ABLE MARINE ENERGY PARK (MATERIAL CHANGE 2 – TR030006)

UPDATED ENVIRONMENTAL STATEMENT

CHAPTER 4: DESCRIPTION OF CHANGES TO DEVELOPMENT & ALTERNATIVES

SLR Ref: 416.01148.00005
Version No: FINAL
June 2021

Scale:	Drawn By:	Checked By:	Approved By:
NTS@A1	D Almeida	R Crum	R Crum
Date:	07/12/2020	12/02/2021	12/02/2021
Drawing No:	AME-036-10009	Revision:	C

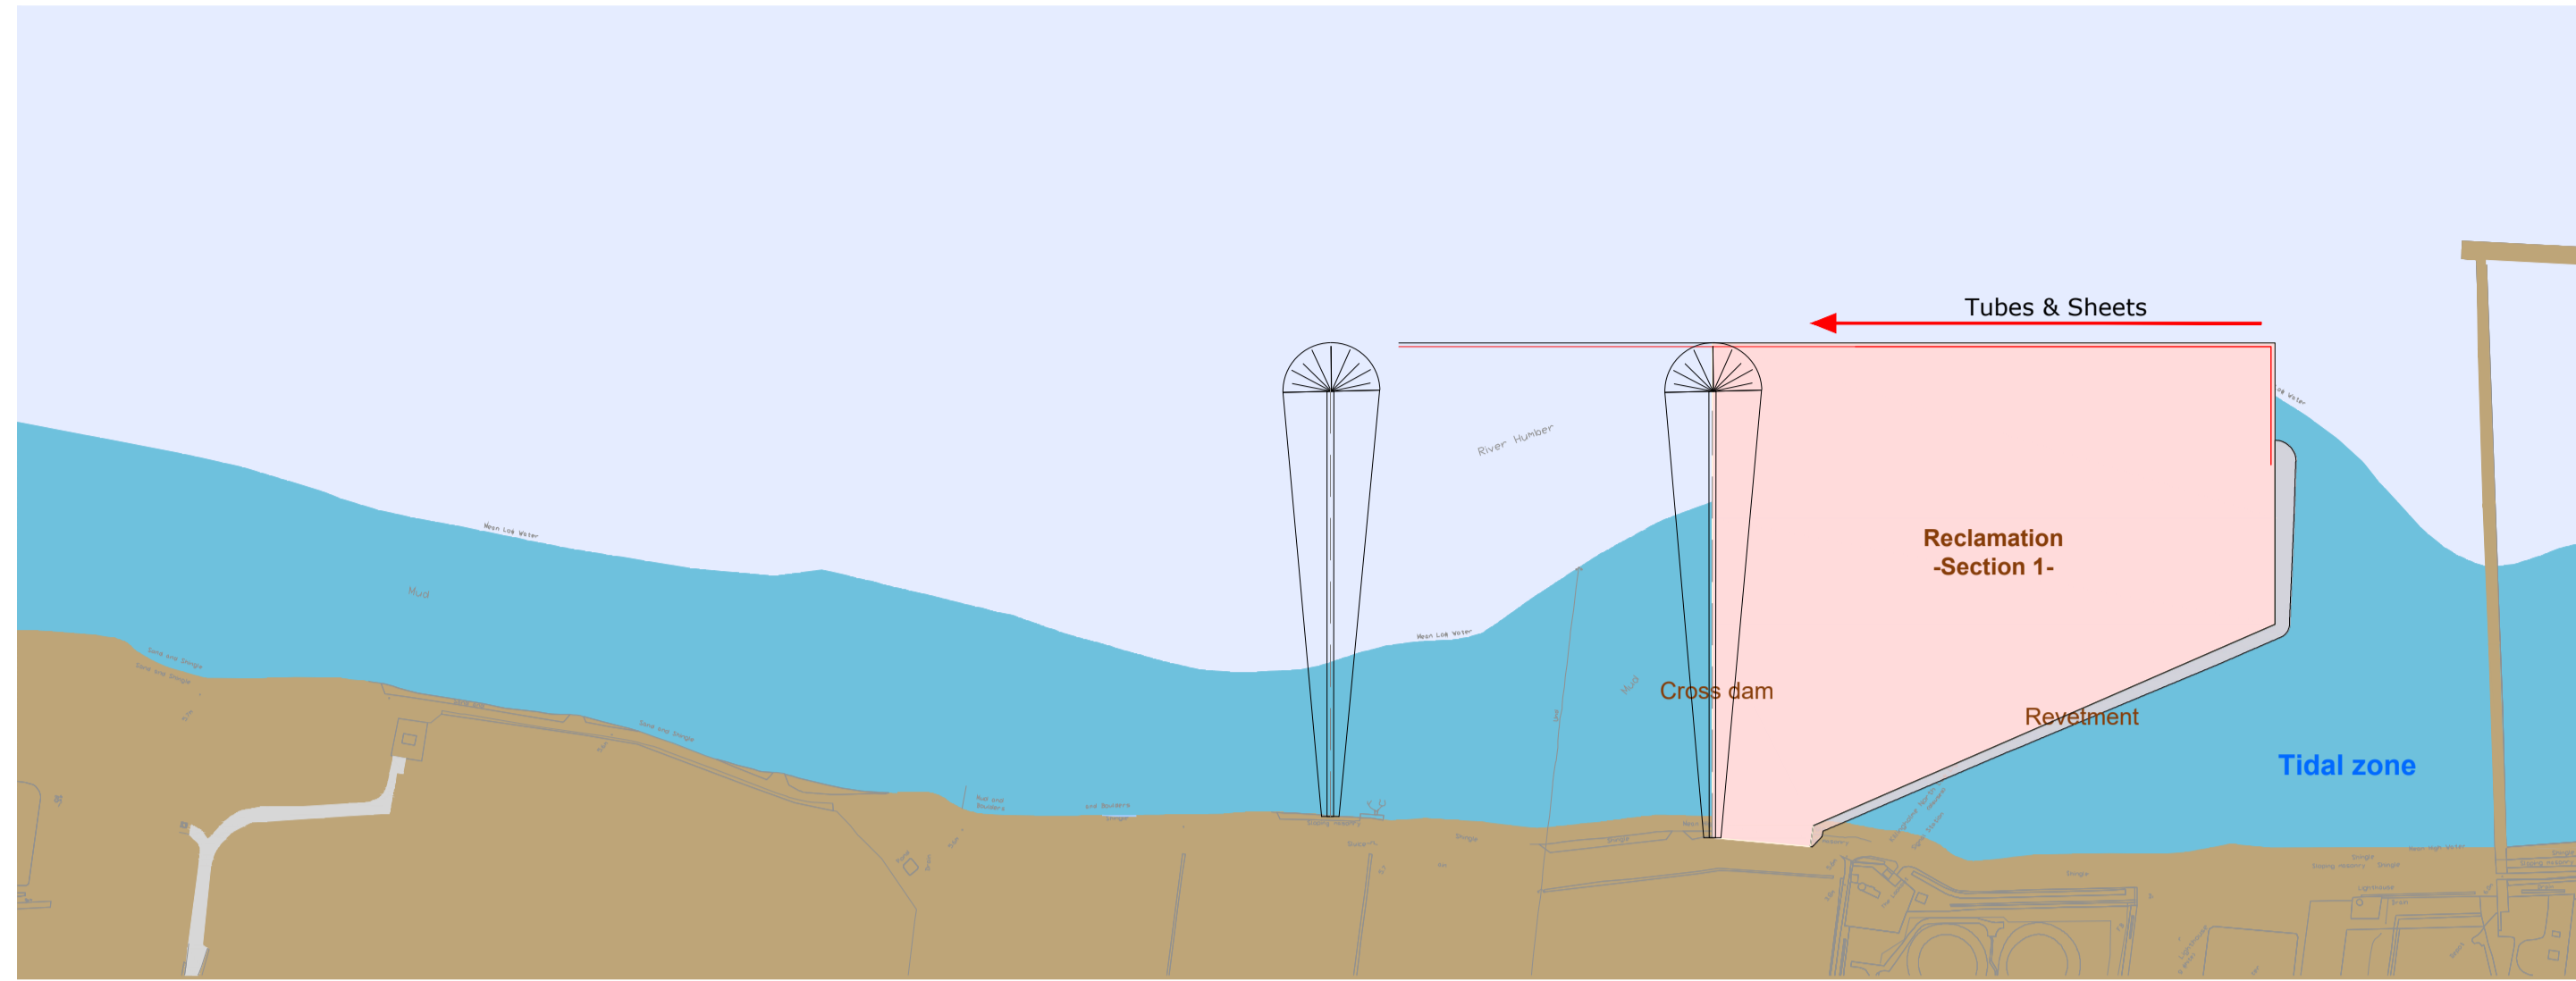
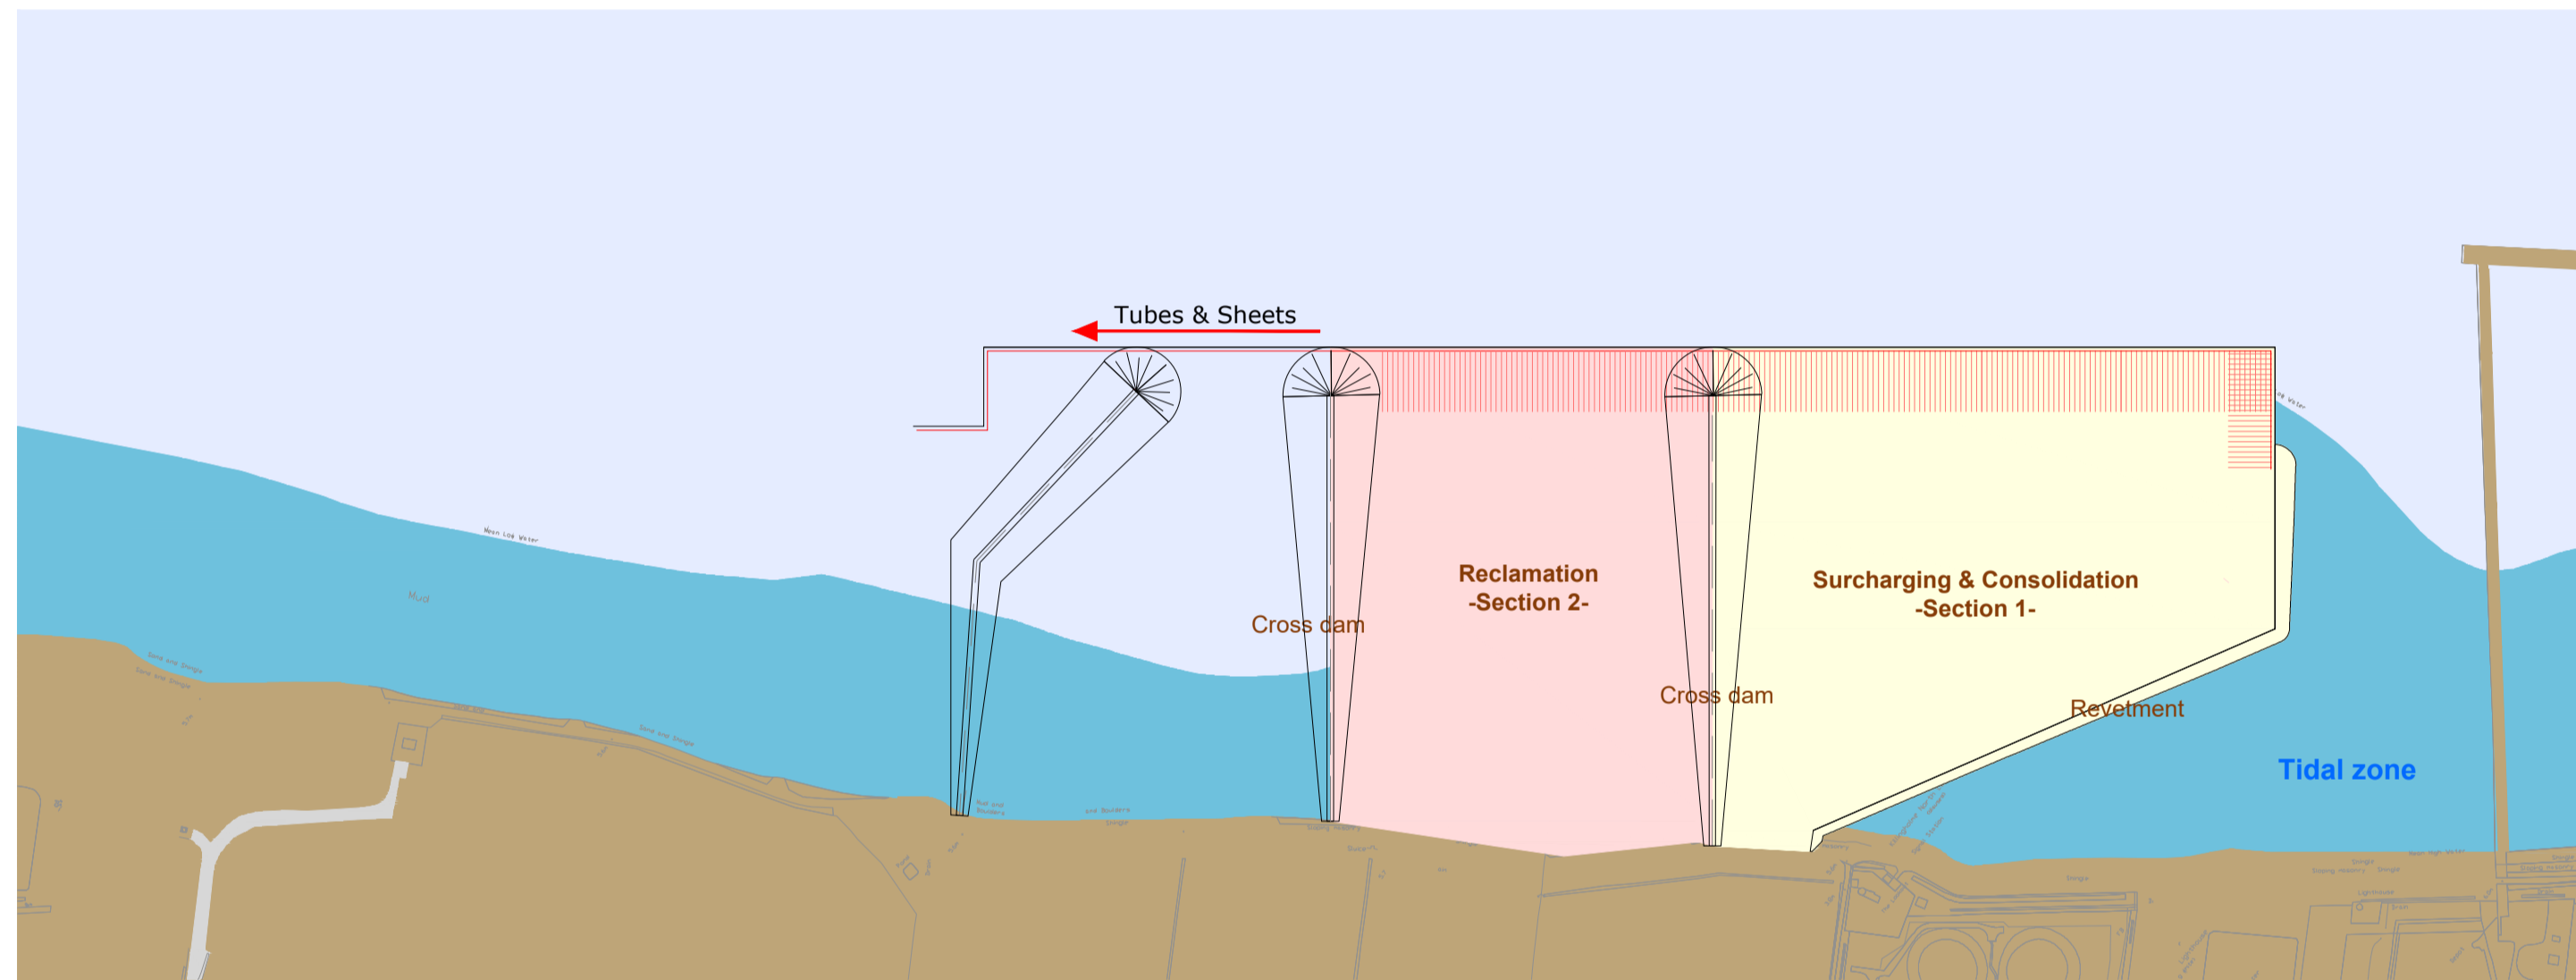
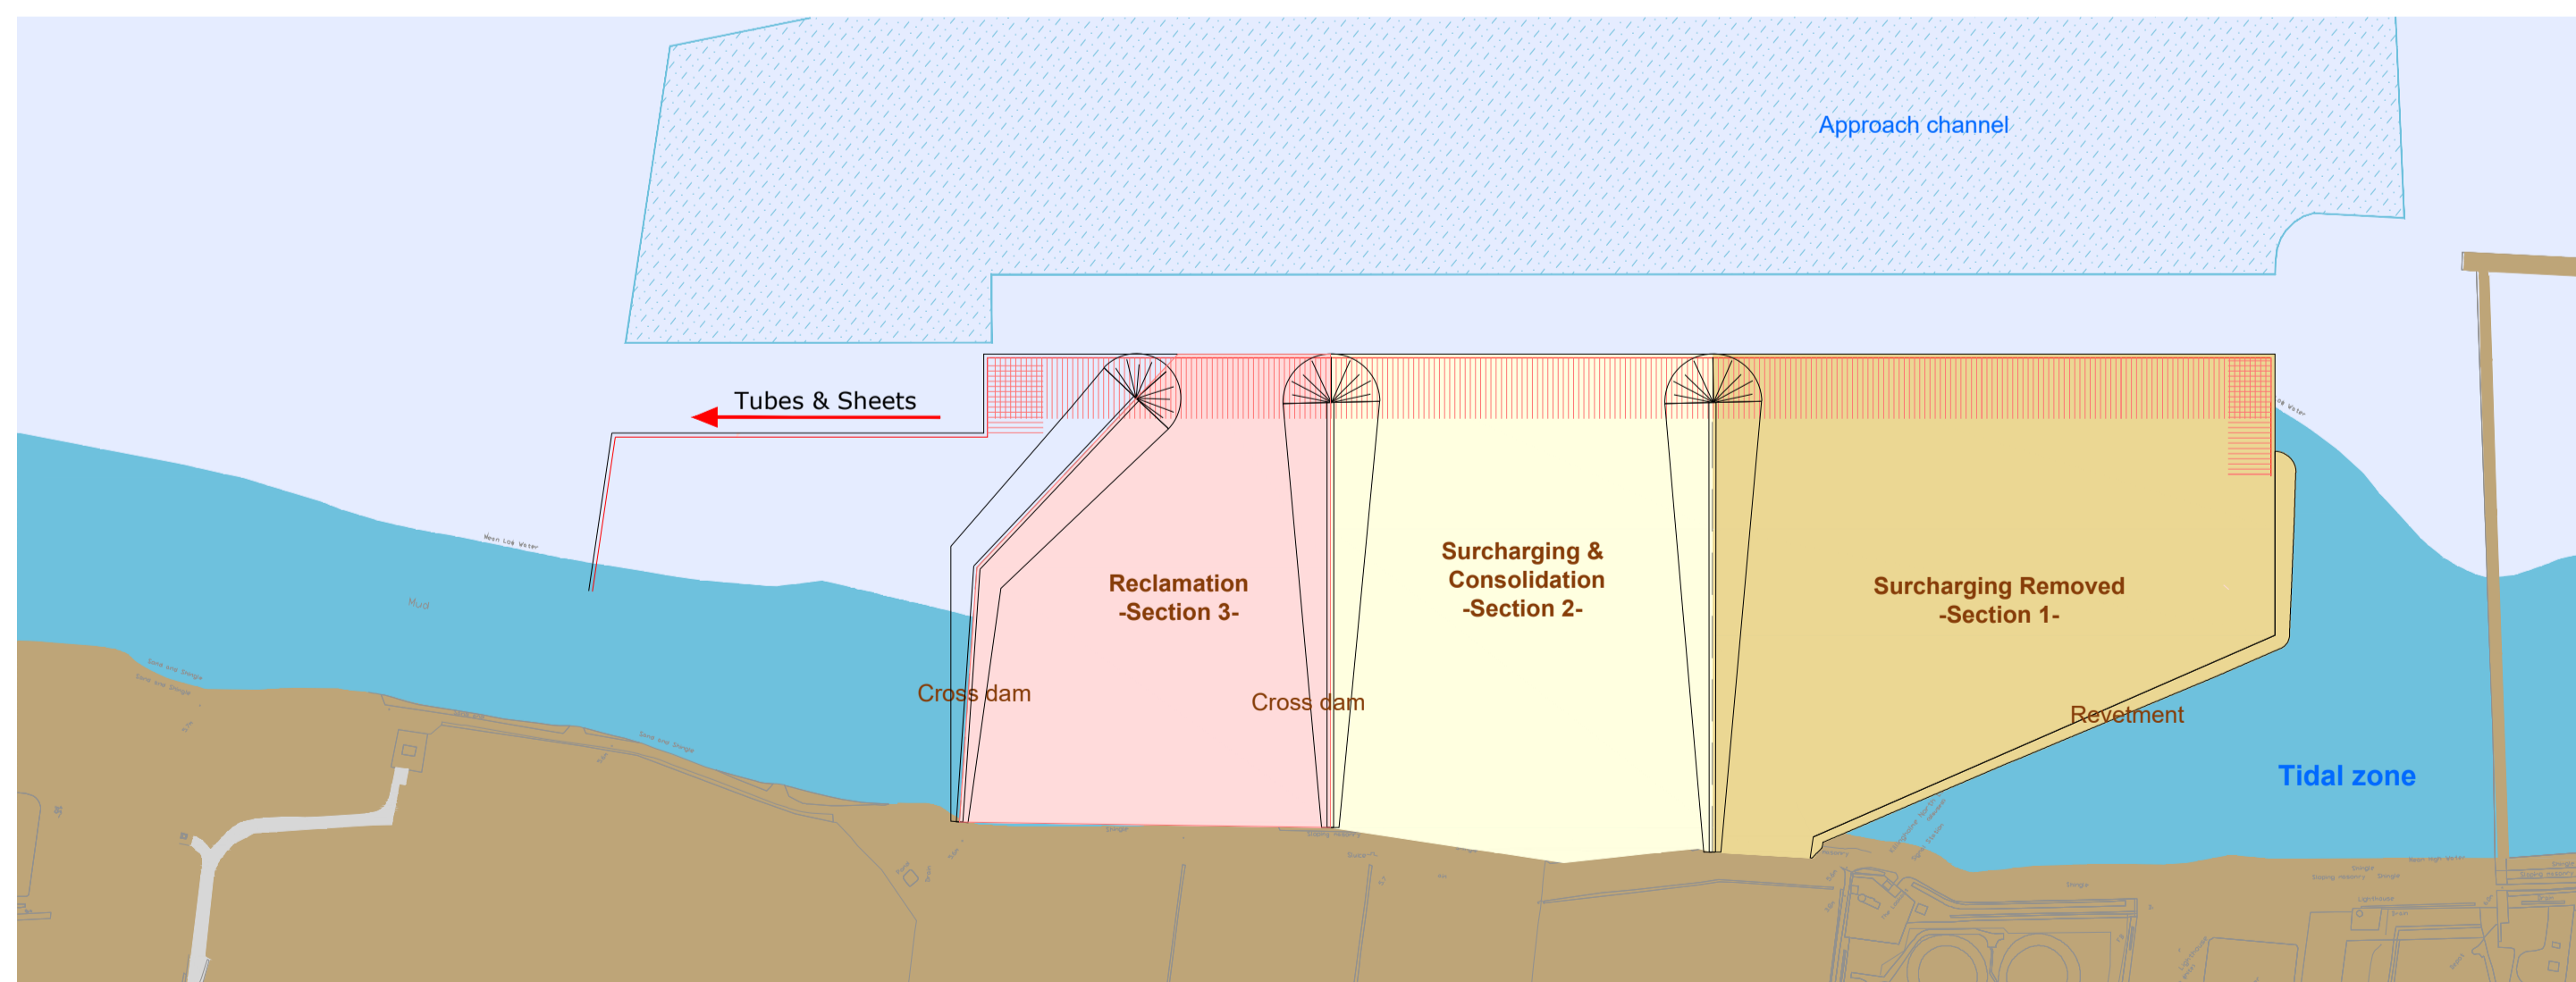
- 4.3.15 In order to facilitate early handover of an operational section of quay, the works are now proposed to commence at the southern end of the quay and progress northwards. On this basis, the construction sequence shown on the DCO approved drawings AMEP_P1D_D_101 to 103 is proposed to be amended, and thereby superseded, by the alternative sequence shown on application drawings AME-036-10009 to 10011 which are included in Appendix UES4-1.
